Please see attached updated drawings and refer to my notes in red below to clarify LCC comments.

Drawing No:
19310-EDGE-XX-XX-DR-C-C2001

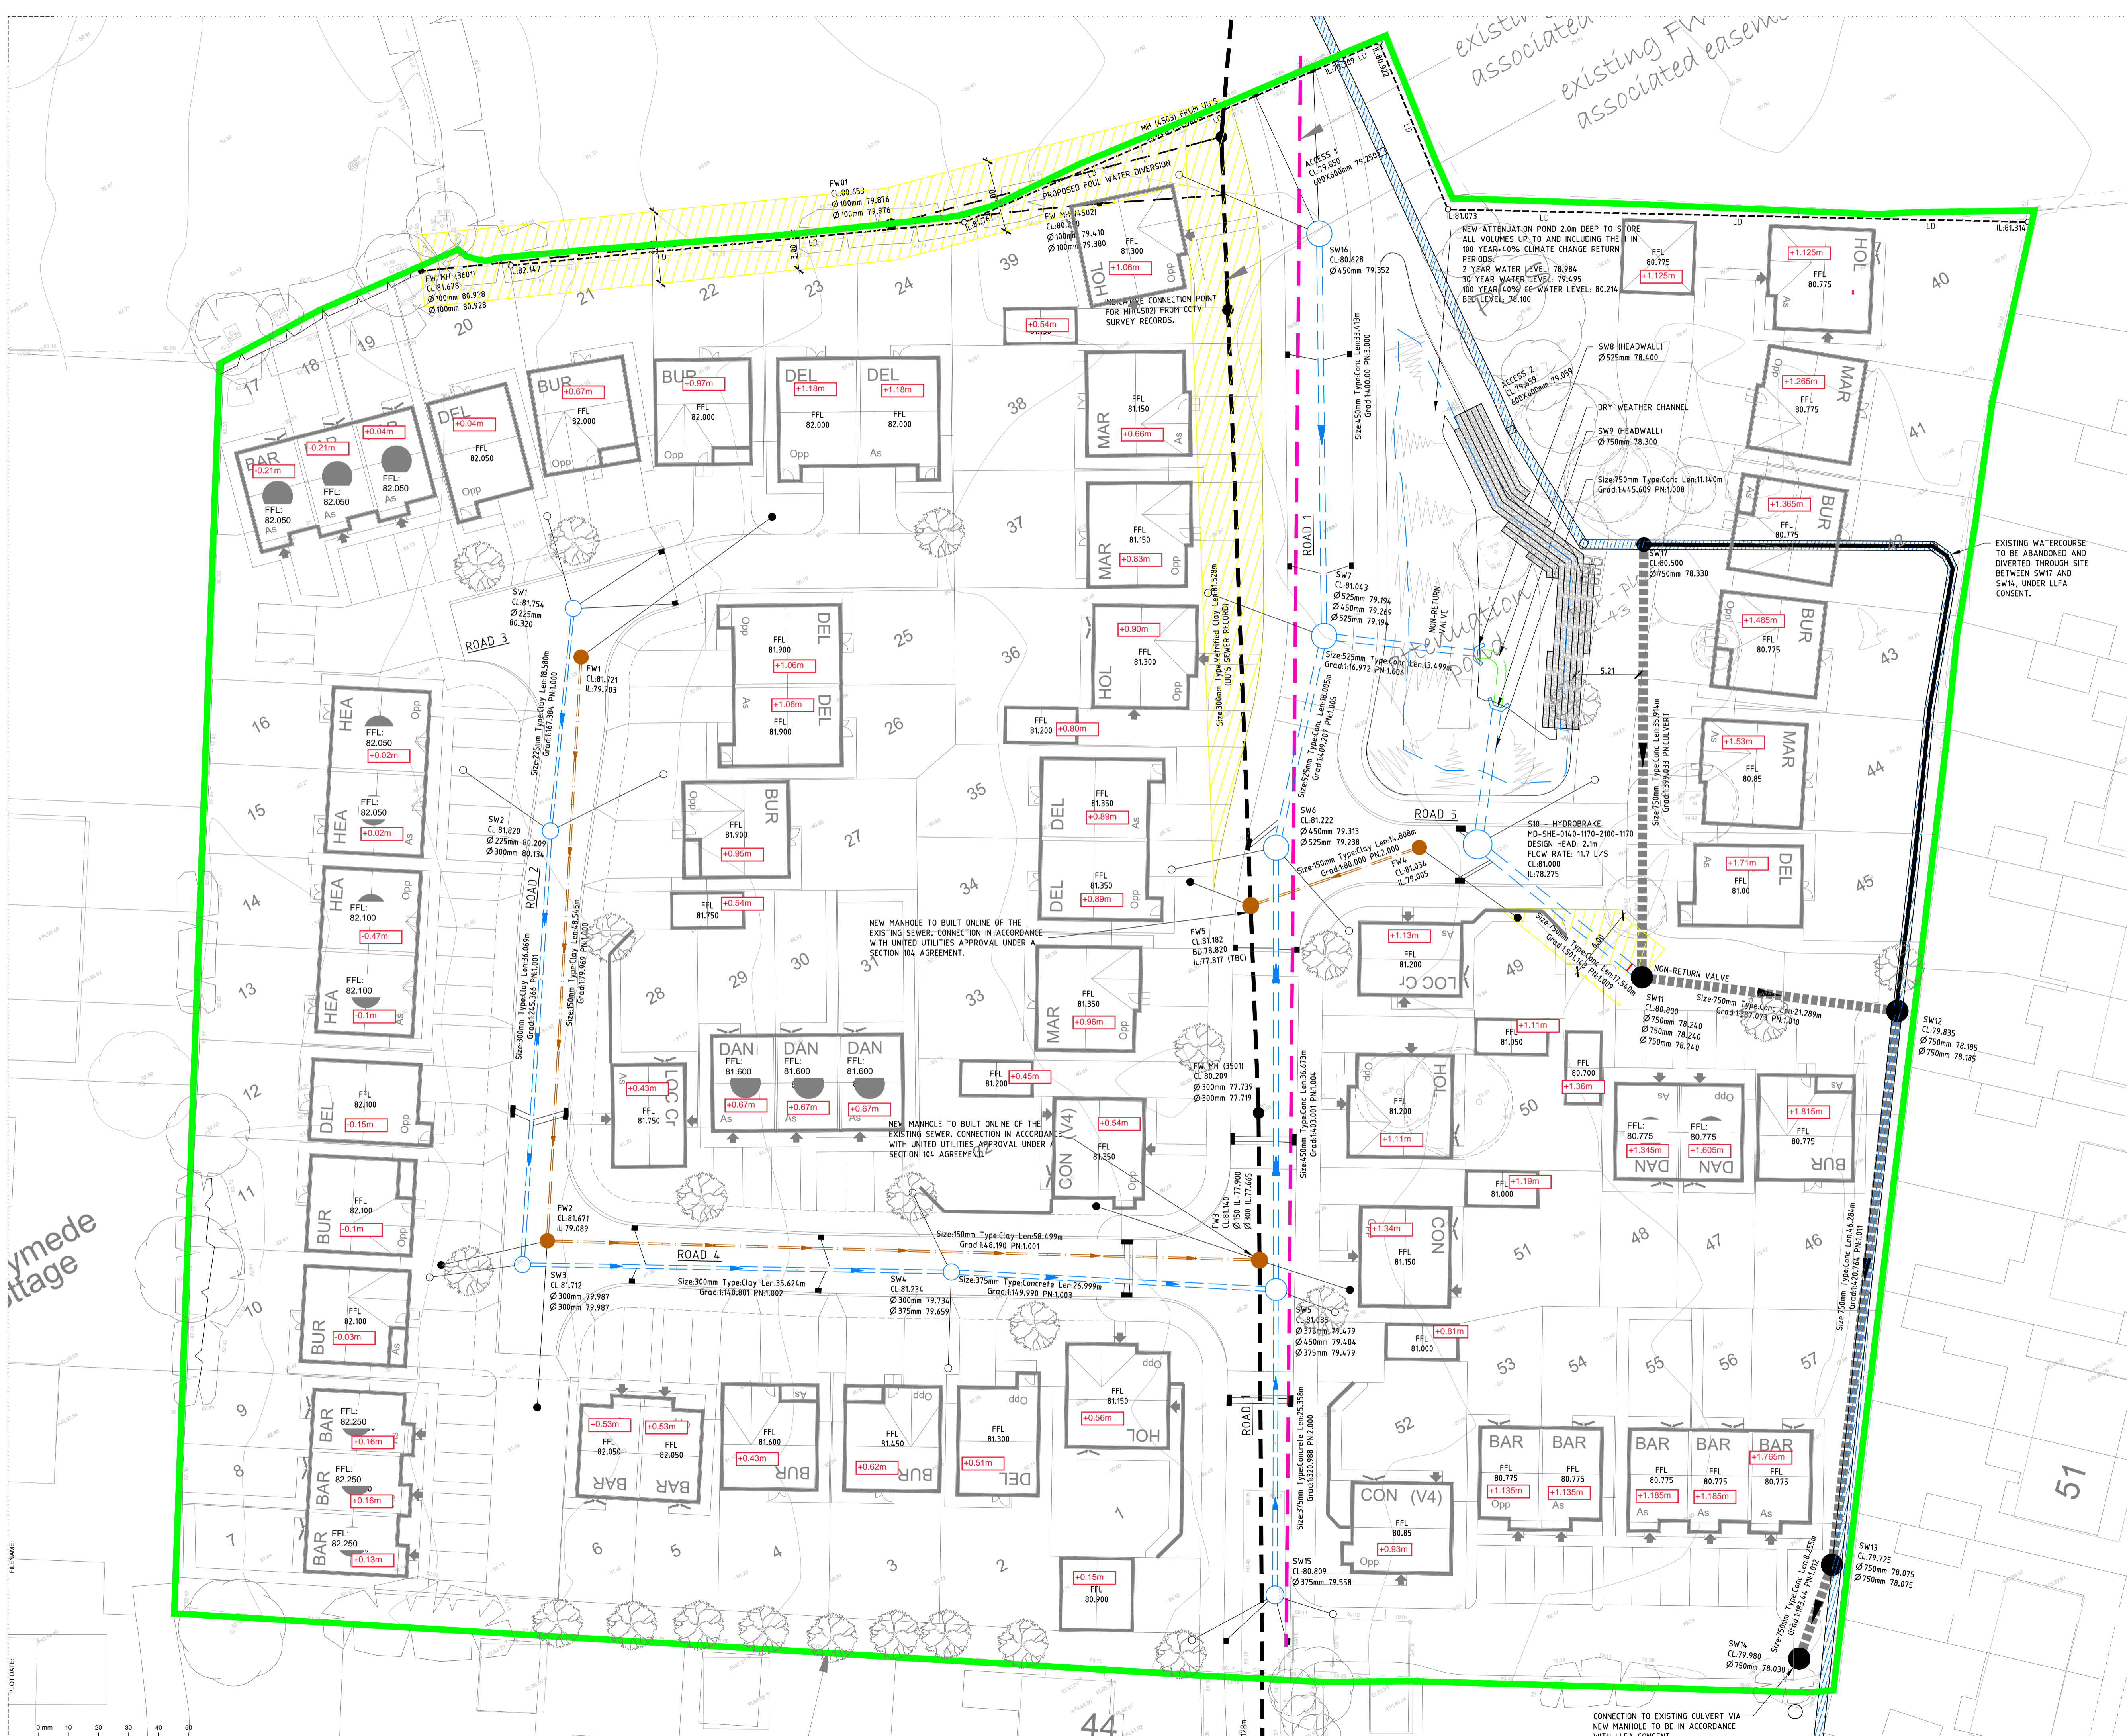
3. Flood Water Exceedance routes

The Lead Local Flood Authority acknowledges the drainage layout that was submitted, this however only depicts an area of exceedance around the surface water attenuation pond, we would expect to see the surface water flow routes for the whole site, in order to establish the path and direction that surface water would take due to road and cover levels for example in the event that the system became overloaded or flooding to occur on site in access of the 1 in 200 year event plus climate change. **Please refer to drawing 19310-EDGE-XX-XX-DR-C-C-2009_FLOOD ROUTING PLAN[P02] for the exceedance plan showing flooding routes for extreme events (calculations undertaken for 1 in 200 year plus climate change) or in case of system failure.**
